Intermodal Logistics Centre at Enfield

**Modification Application No. 6
ECI Detailed Design Adjustments
and Subdivision**

Response to Submissions

July 2012

**ILC AT ENFIELD
 SITE LAYOUT**

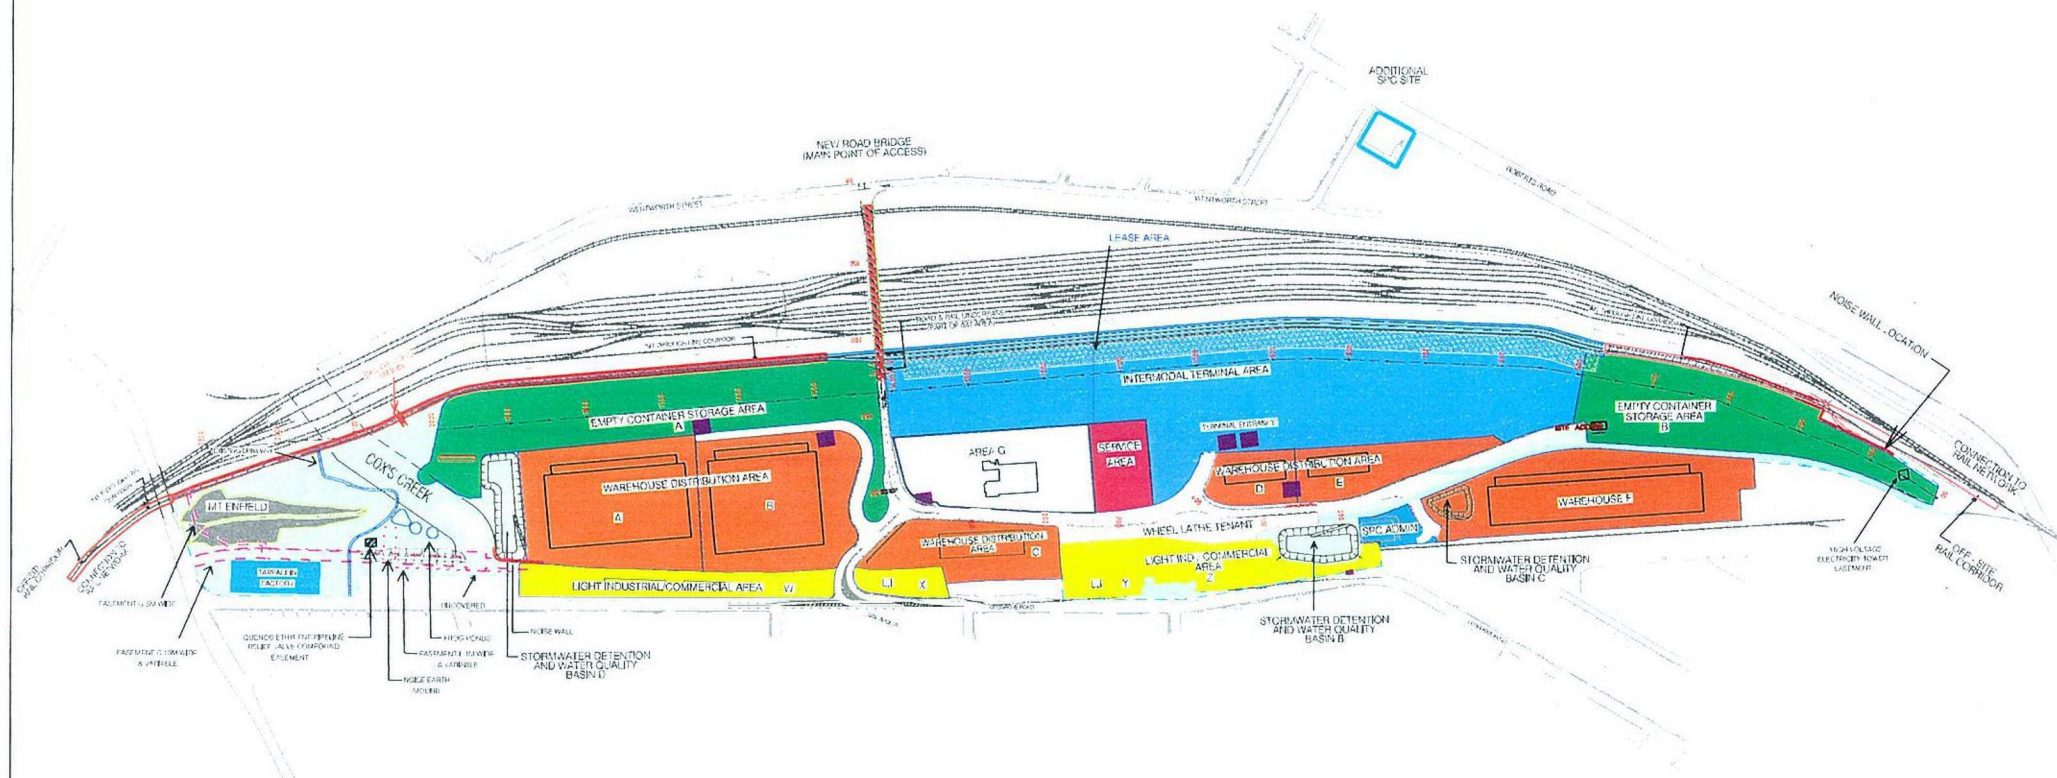
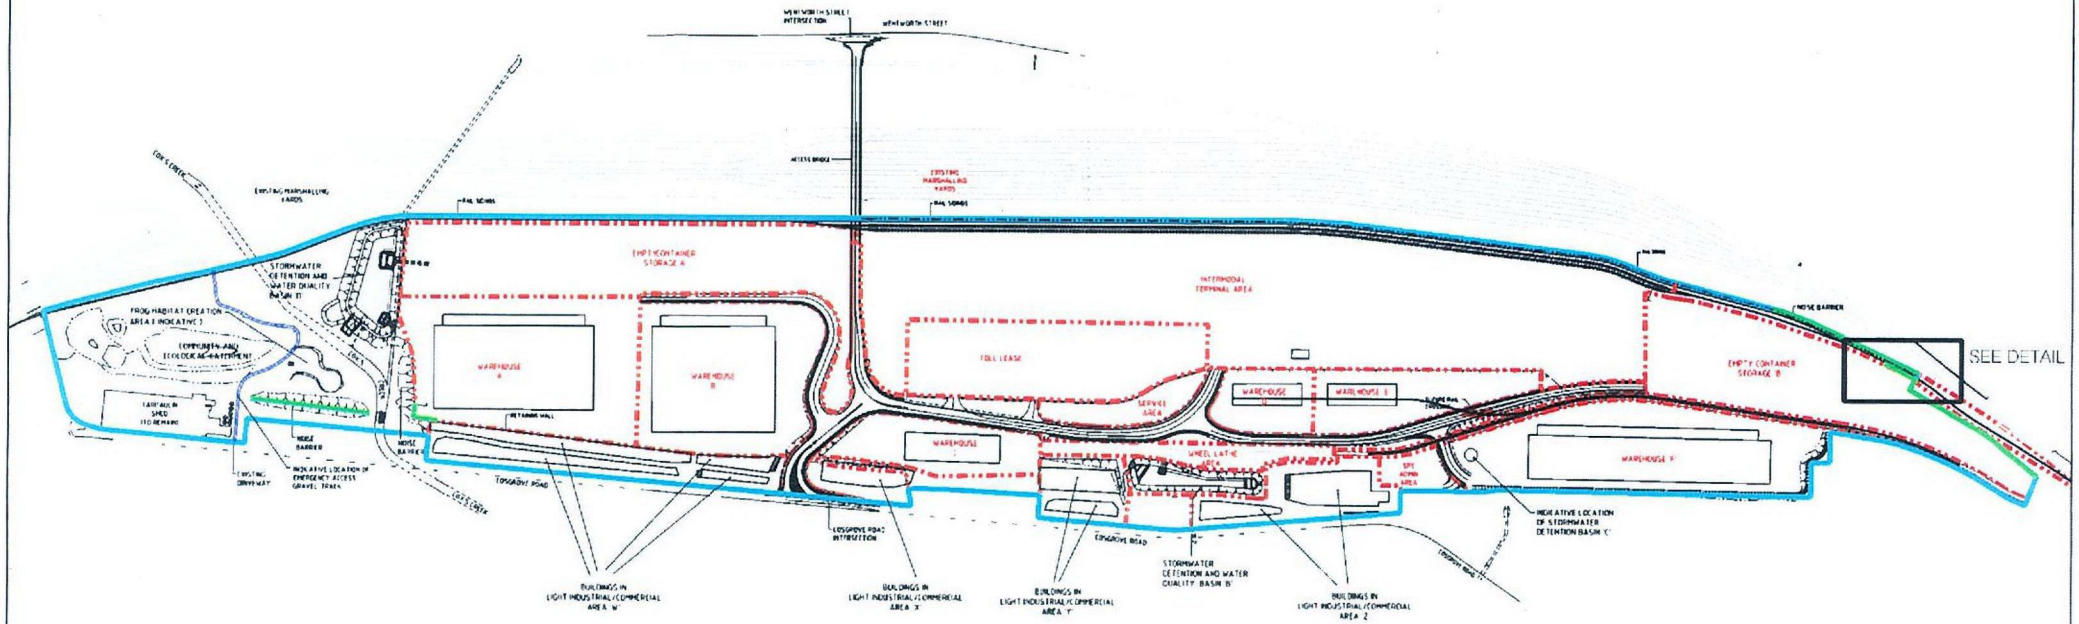
SMC's submission raised concerns that the proposed method of stormwater runoff management shown on Figure 3 of the Modification 6 report does not meet Council's standard requirements. SMC's submission states that "*stormwater runoff from each sub-catchment shall be collected and discharged to the existing downstream drainage culvert via On-site Stormwater Detention Storage.*"

SMC commented that the Ecological and Community Area should be labelled on the plan and should include all of the land south of Coxs Creek. Sydney Ports notes that the Ecological and Community Area does include all of the land south of Coxs Creek. Figure 3 of Modification 6, included as Figure 1 in this Response to Submission Report, has been amended to show this more clearly.

SMC also commented that the amount of general landscape areas along the eastern side of the site has been reduced. Sydney Ports notes areas of general landscaping have not been reduced. The layout plan has been amended to show the proposed landscaping/vegetated areas on the eastern side of the site. Landscaping areas within the site have been increased from Modification 4, because retaining walls within the site have been replaced with grassed batters. The batters will be vegetated with a native grass mix similar to what has been approved for areas of the southern ecological area. Figure 1 shows the proposed vegetated areas.

Figure 3 of Modification 6 (refer Figure 1 of this Response to Submissions Report) show that runoff from the site sub-catchments are directed to Detention Basins B, C or D for both flow attenuation and water quality treatment. Drawings showing the catchments draining to each basin and the discharge points for each basin are provided in Appendix C.

The results provided in Table 2.2 above demonstrate that the stormwater detention system has been designed in accordance with the SMC's *Stormwater Management Code* (October 1994) such that post development flows are limited to pre-development conditions for storm events up to the 100 year ARI event.

The ILC tenants and operators will be required to carry out landscaping within their lease areas in accordance with the layout shown in Figure 1.

Figure 2 Southern L-shaped barrier - Updated

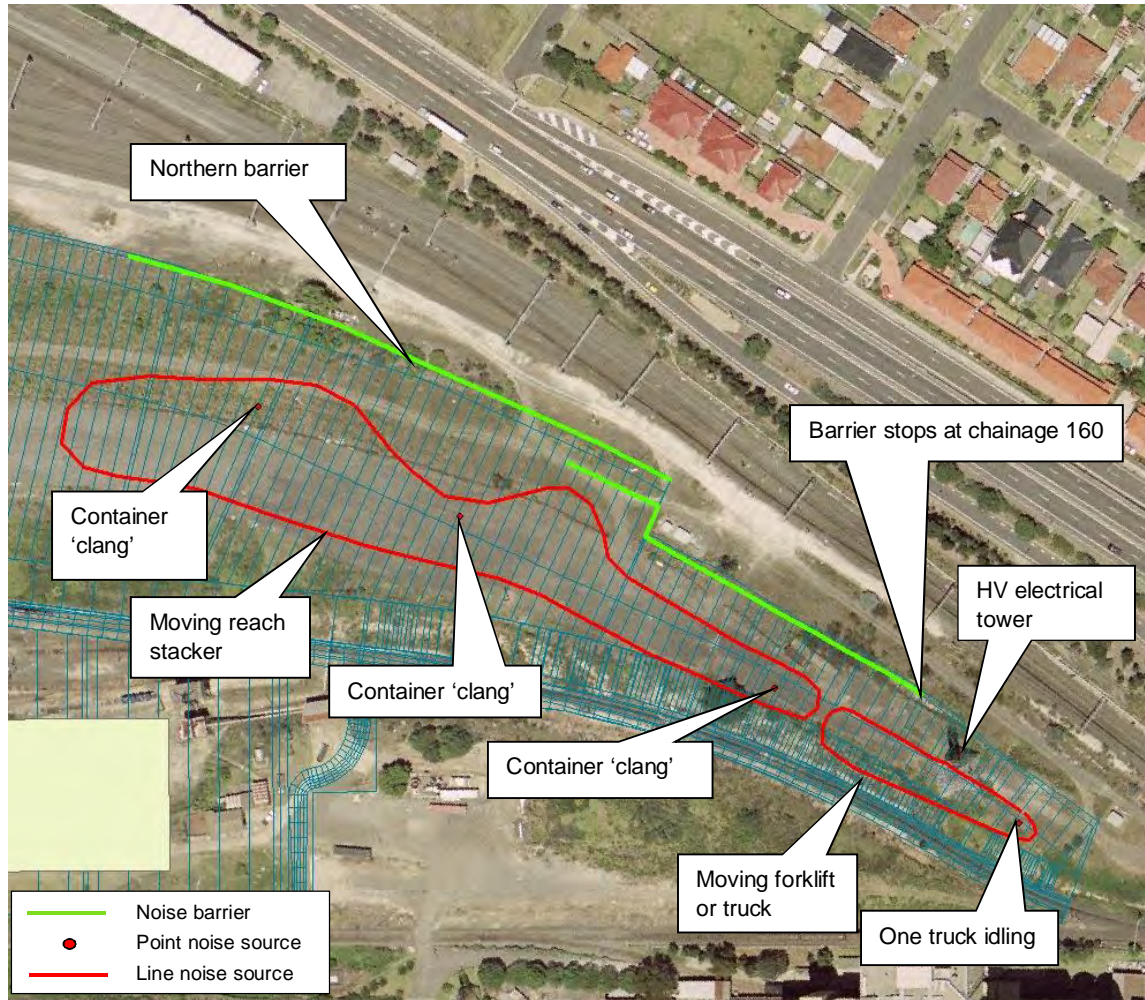
Both DP&I and EPA noted that the full acoustic assessment should be provided to enable a thorough consideration of the proposed changes to be made and that the proposed changes should be assessed against the maximum allowable noise contributions in CoA 2.17 under worst case meteorological conditions. The EPA further advised that the existing noise criteria in the approval for the project should remain unchanged and SMC stated that the noise criteria should be met at all times under all operating conditions. The full acoustic assessment, which is attached as Appendix B to this report, is based on the most likely operating scenarios and a range of weather conditions including the worst case scenarios.

The detailed acoustic assessment indicates that the changes proposed in Modification Application 6 would comply with the maximum allowable noise contributions set out in CoA 2.17 subject to the implementation of as many of the following measures as necessary, tailored in response to final operating and site layout scenarios, to meet the noise criteria in Condition of Approval No 2.17. These measures are consistent with operational measures previously approved in Modification Application 4 which is referenced in CoA 2.19A:
